Kittitas County Community
Development Services
411 N Ruby St. Ste 2
Ellensburg, WA 98926

I am Ninon Wheatley, president of the Thorp Mill Ditch Users Association, Inc. I have concerns with the application for Conditional use permit # CU-14-00001 submitted by the GT Ranch LLC.

# Pond 1

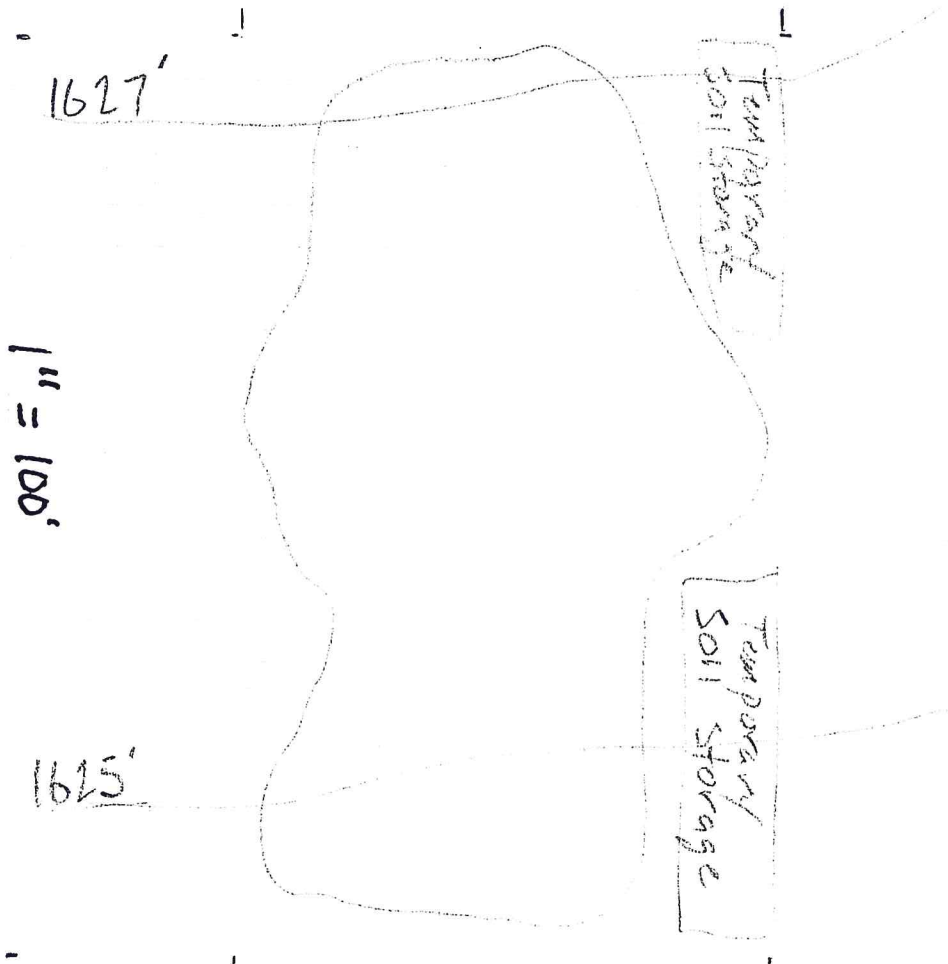
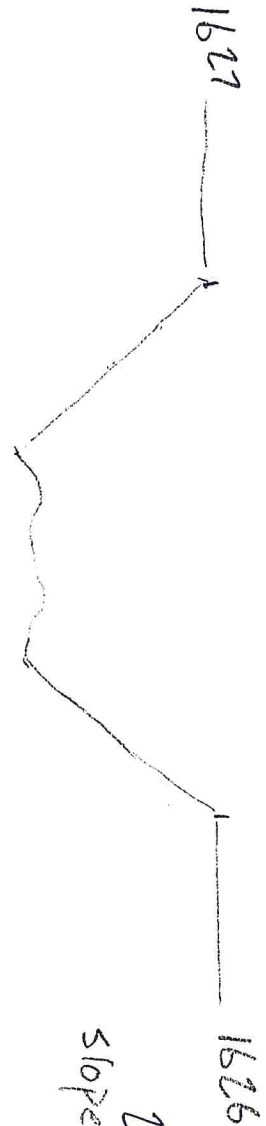
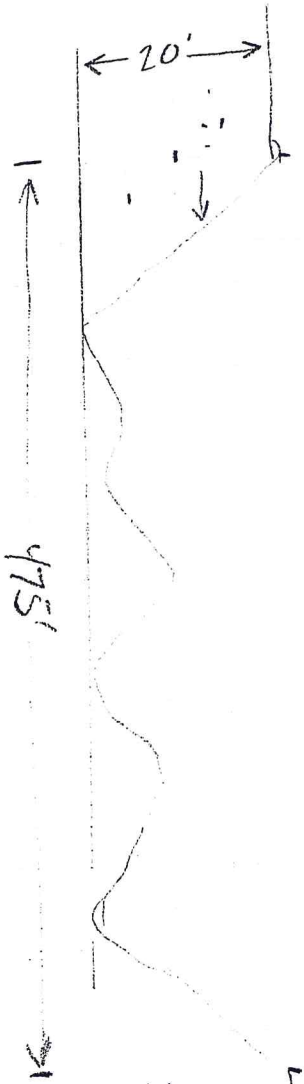
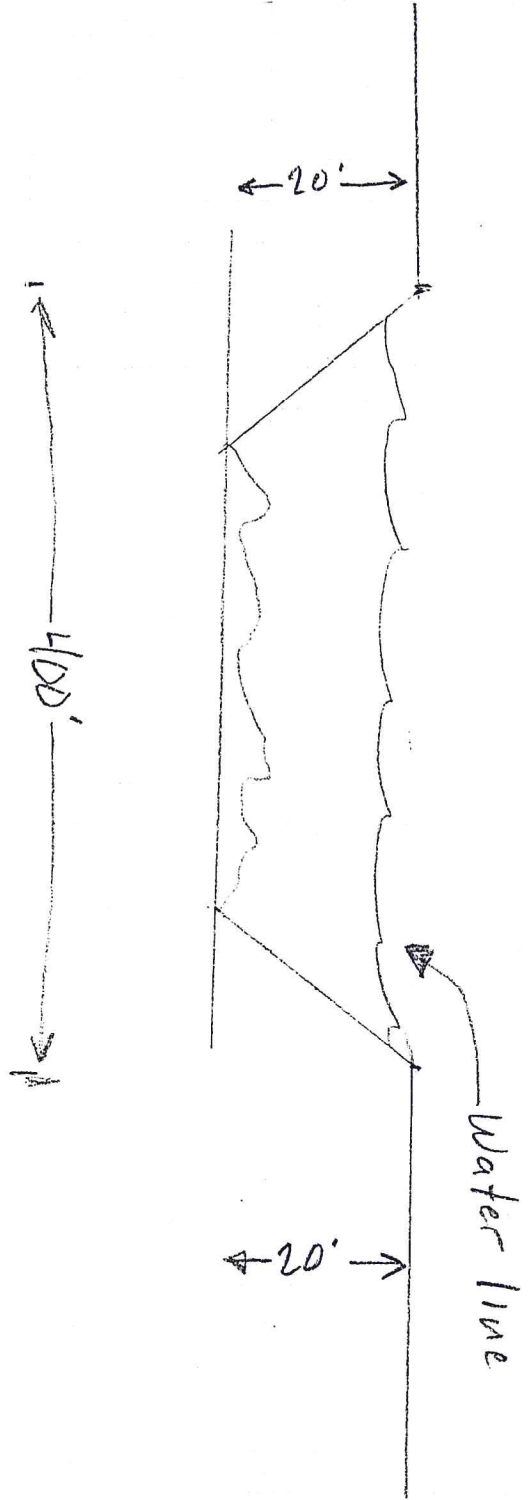
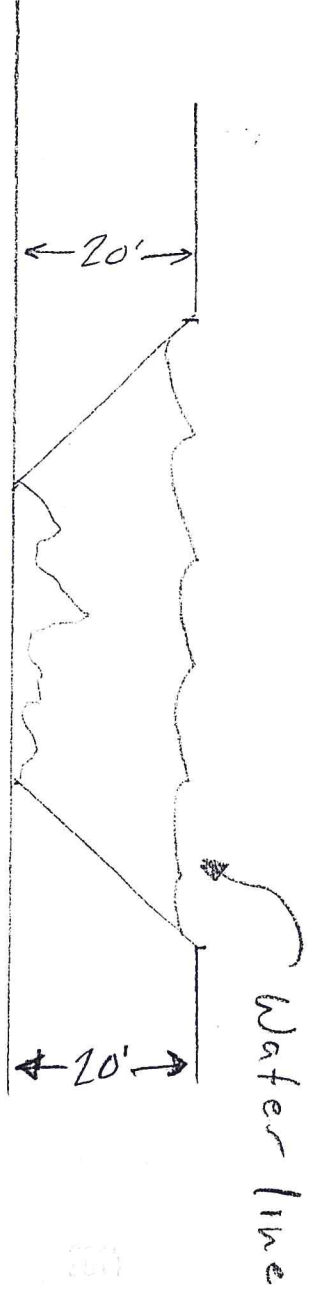
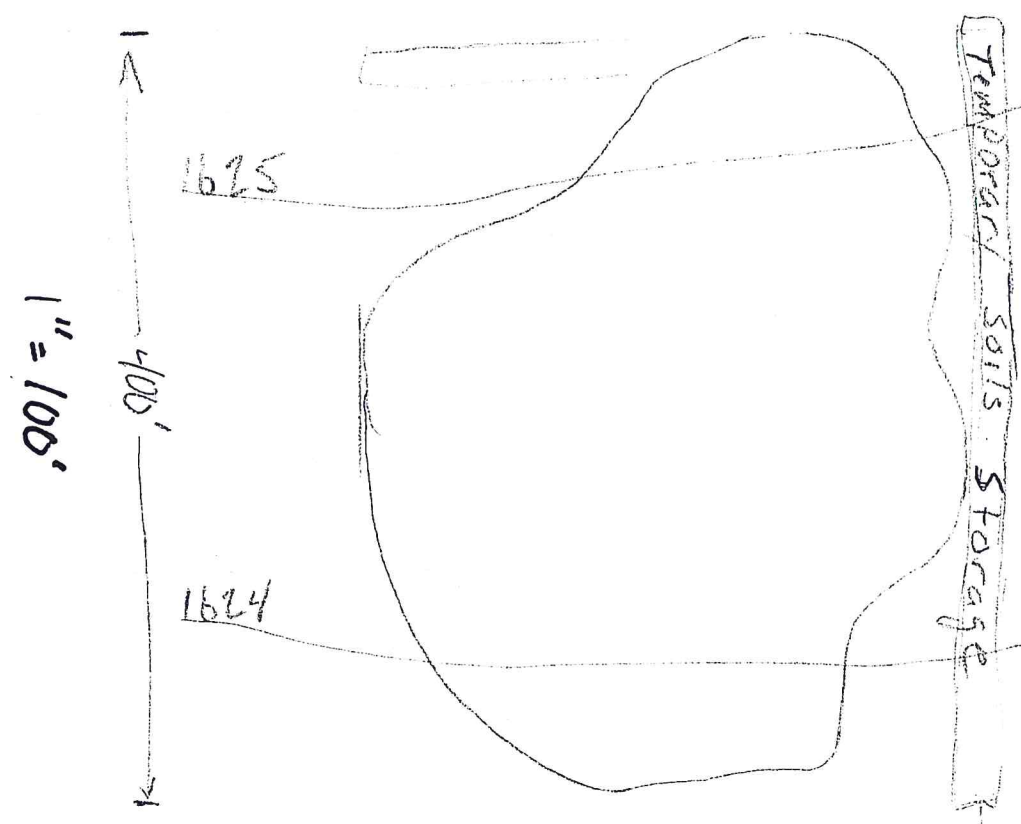
My second concern: Possible affects of irrigation water rights for users below the proposed site. How can we be guaranteed that digging of the ponds and removal of the material for construction will not alter or temporarily stop the flow of the Thorp mill ditch for our users who are below the proposed site?
